Jaynes Property Sketch Plan, SKP-22-5

Please accept the following updated comments from El Paso County Public Health (EPCPH) regarding the 143-acre, approximately 450 residential lot, 2 parks, and commercial area proposed development:

Mike McCarthy
El Paso County Public Health
mikemccarthy@elpasoco.com
719-332-5771
20Jan2023

## SKETCH PLAN

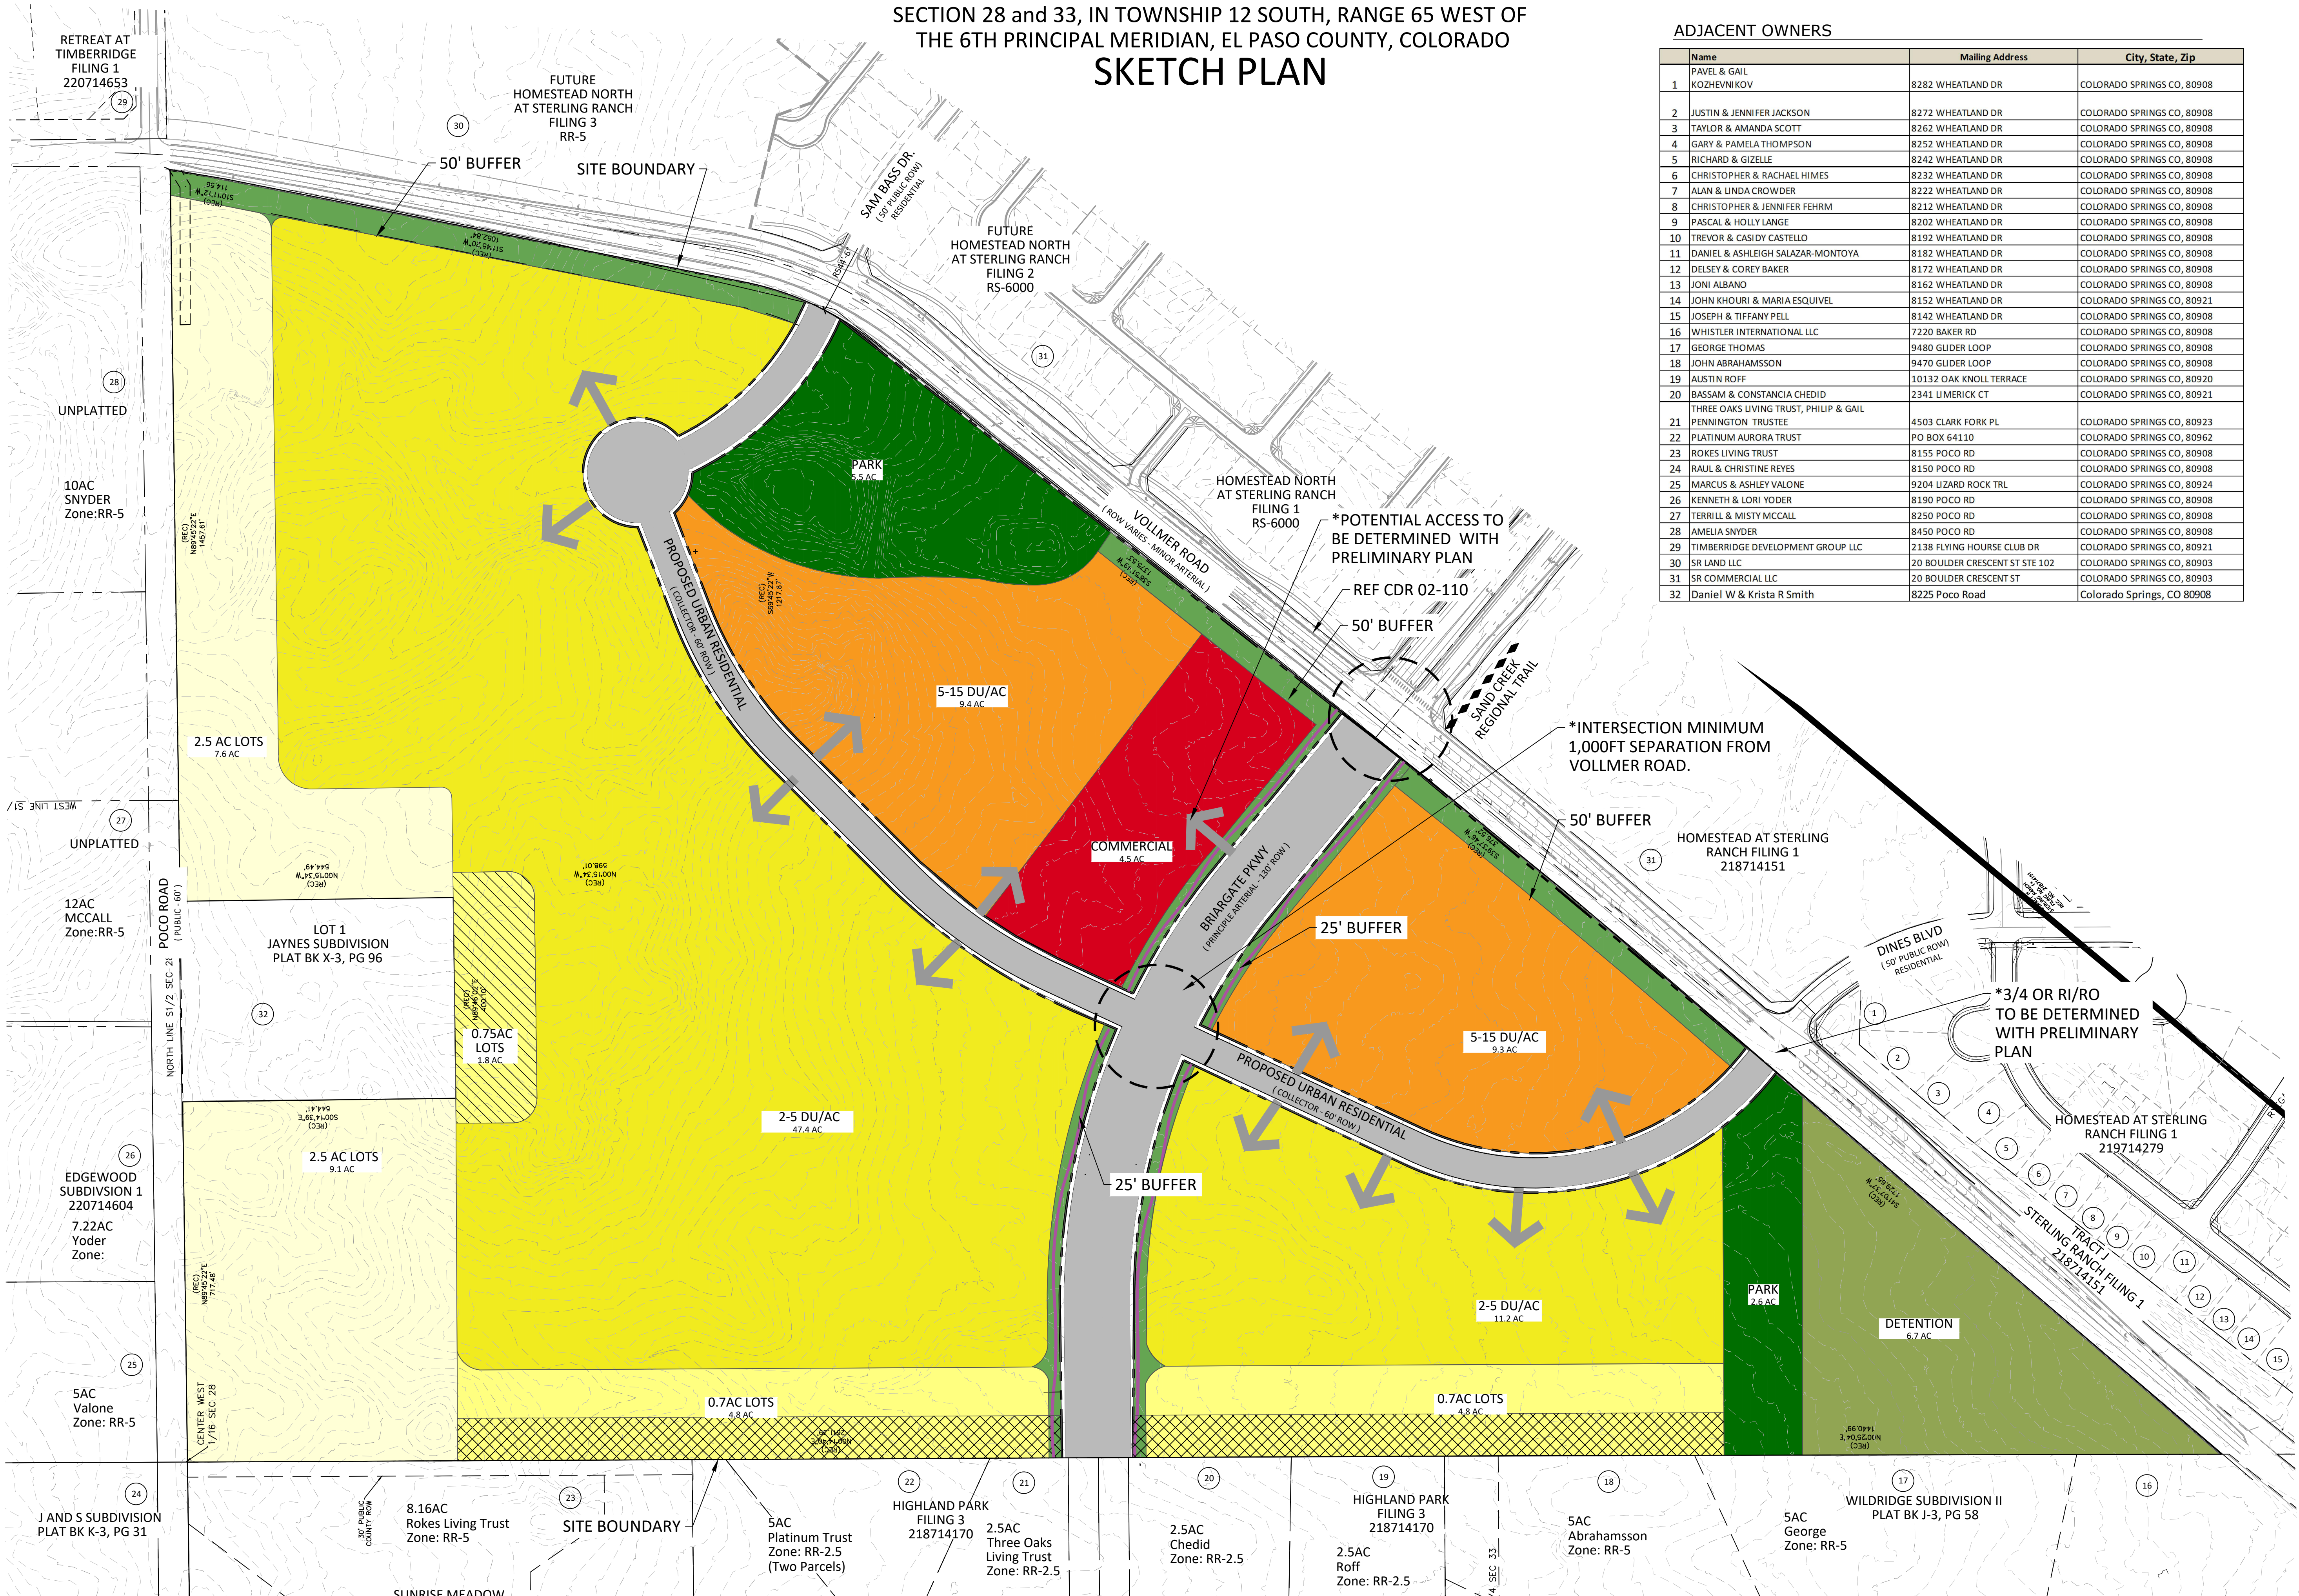
- **El Paso County Public Health encourages planned walkability of residential and commercial areas. Please consider appropriate connections to commercial areas with sidewalks, and bike trails. Walkability features help reduce obesity and associated heart diseases.**
